For attention of Stuart Cowperthwaite
Development Consent Order for HE project TR0 10022

AS-058 Water environment

These photos were taken on Thursday 19th March on site at Markeaton Park adjacent to the A38. They confirm my submission about the embankment becoming saturated with water when plants are not removing the water by transpiration. They support the concerns of Derby City Flood Authority.

FIGURE 2.12C

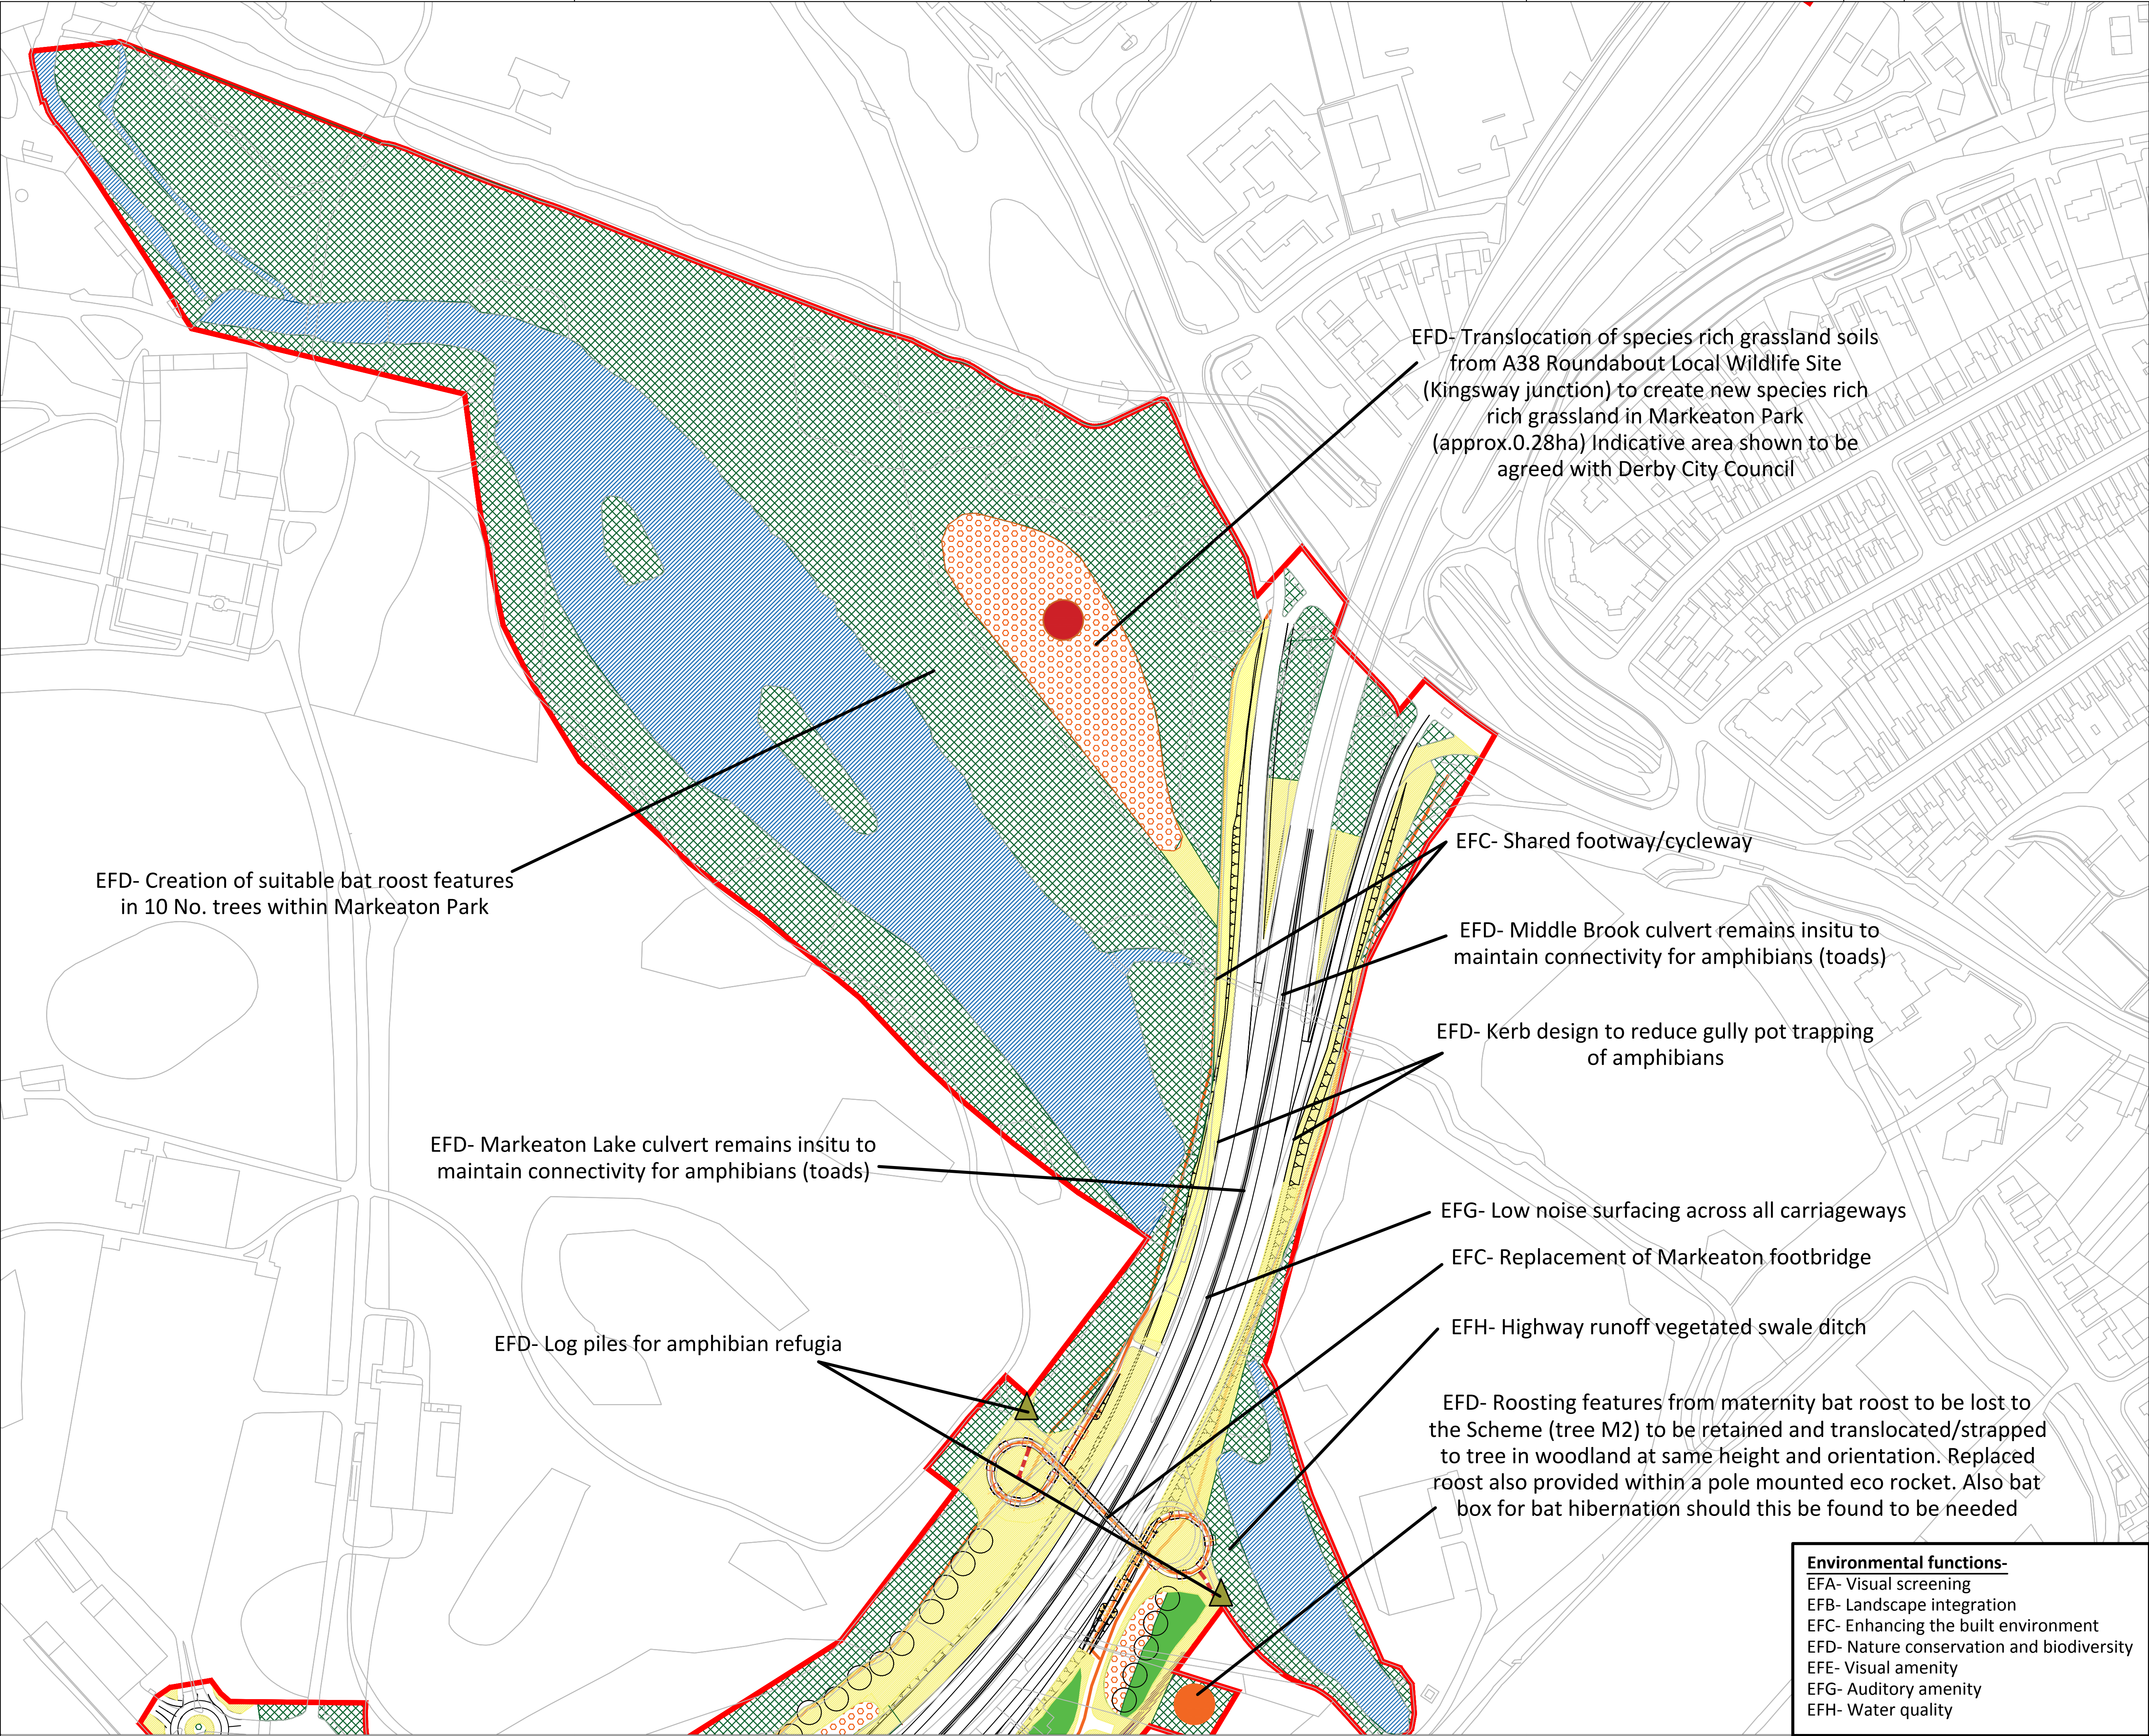
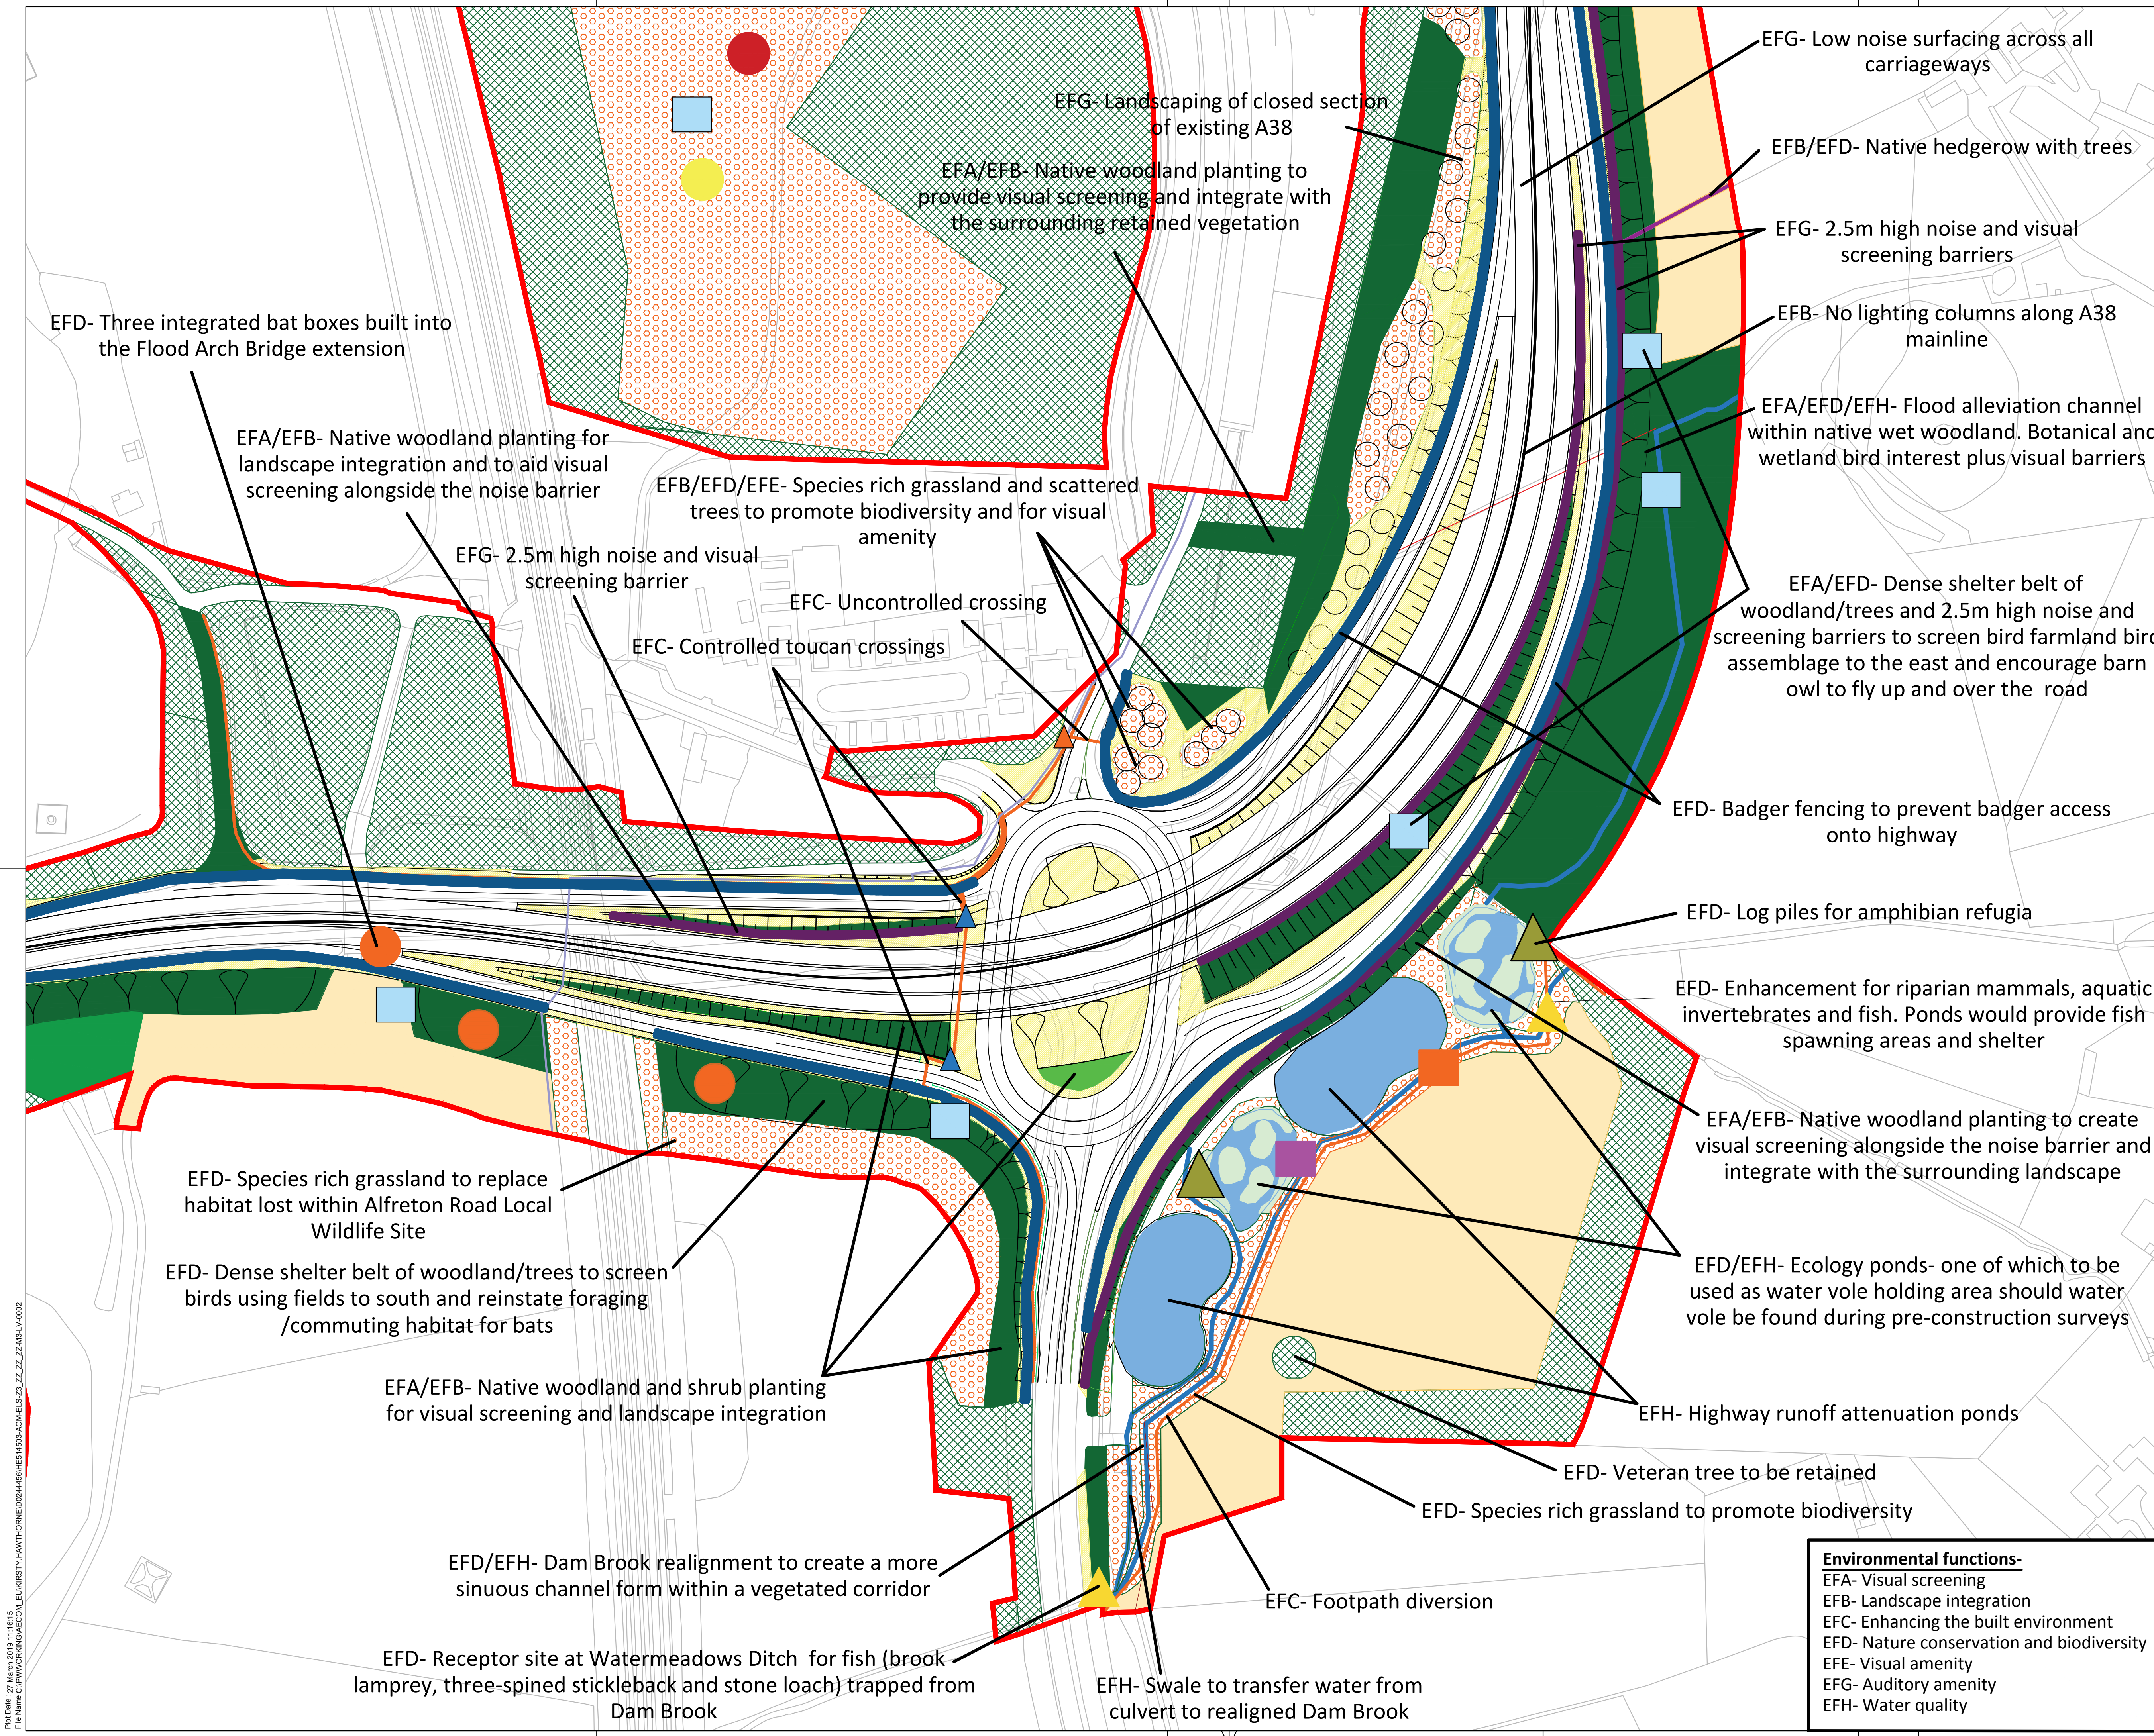
These stems have more suction than one tree, most of the area to be cleared has this type of wooded cover. The amount of water this scrub and wood removes from the ground is not included in the figures in my submission accepted on the 18th March The white dots on the left are vehicles on Queensway.

These plants have established over years, before the extreme rainfall rising from Climate Change. In dry summer times this soil becomes solid. Mitigation plants are not likely to survive, and would not perform the benefits provided by the existing trees and scrub.
